From: planning.scanning@york.gov.uk
Subject: FW: AOD/23/00105 - C2, C6 & 19, C27, C28, C29, C30 - Highway DC comments

From: Vergereau, Helene <Helene.Vergereau@york.gov.uk>
Sent: 04 April 2023 16:25
To: Elliott, William <William.Elliott@york.gov.uk>
Cc: highwaydc@york.gov.uk
Subject: AOD/23/00105 - C2, C6 & 19, C27, C28, C29, C30 - Highway DC comments

C2 detailed drawings for internal road details, etc – **not ready to discharge**

Drawing Title:  
**Site Layout Plan**

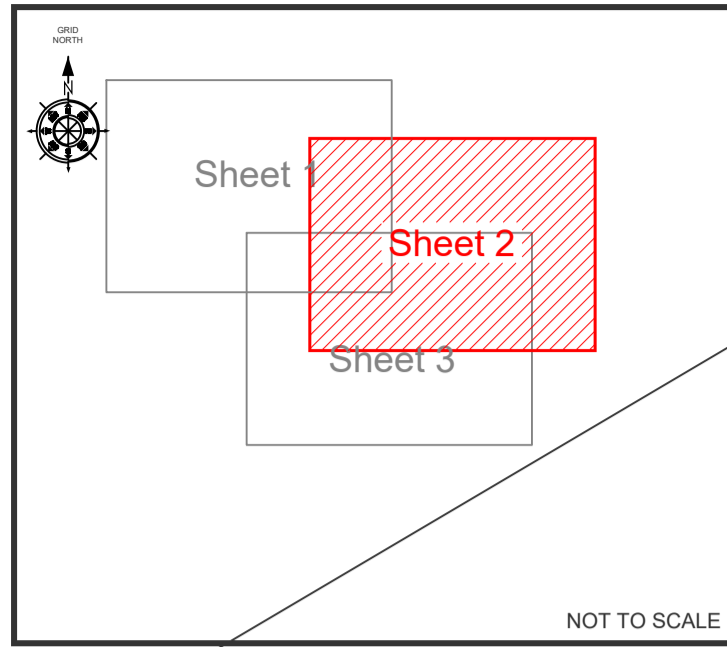
- Site layout plan:
 - There is a cycle lane painted on the road on the wrong side of the carriageway and one way only into the site. at 1m width, it cannot be two way so is inadequate. This needs to be revised to consider LTN 1.20 requirements.

- There is an existing spur or layby opposite the junction with New Road at the entrance to the site. What will this be used for? It seems to be shown as tarmacked.

- There is a layby designed just after the reception building, on the left hand side of the access road. It seems to be approx.. 50m long but only 2m wide. This will not enable vehicles with caravans or camper vans to park/wait without encroaching on the access road.

- How many vehicles are we expecting to arrive/leave at the same time? Can I see come evidence that the layby capacity will be sufficient so that access to other properties/fields in the area can be maintained at all times?
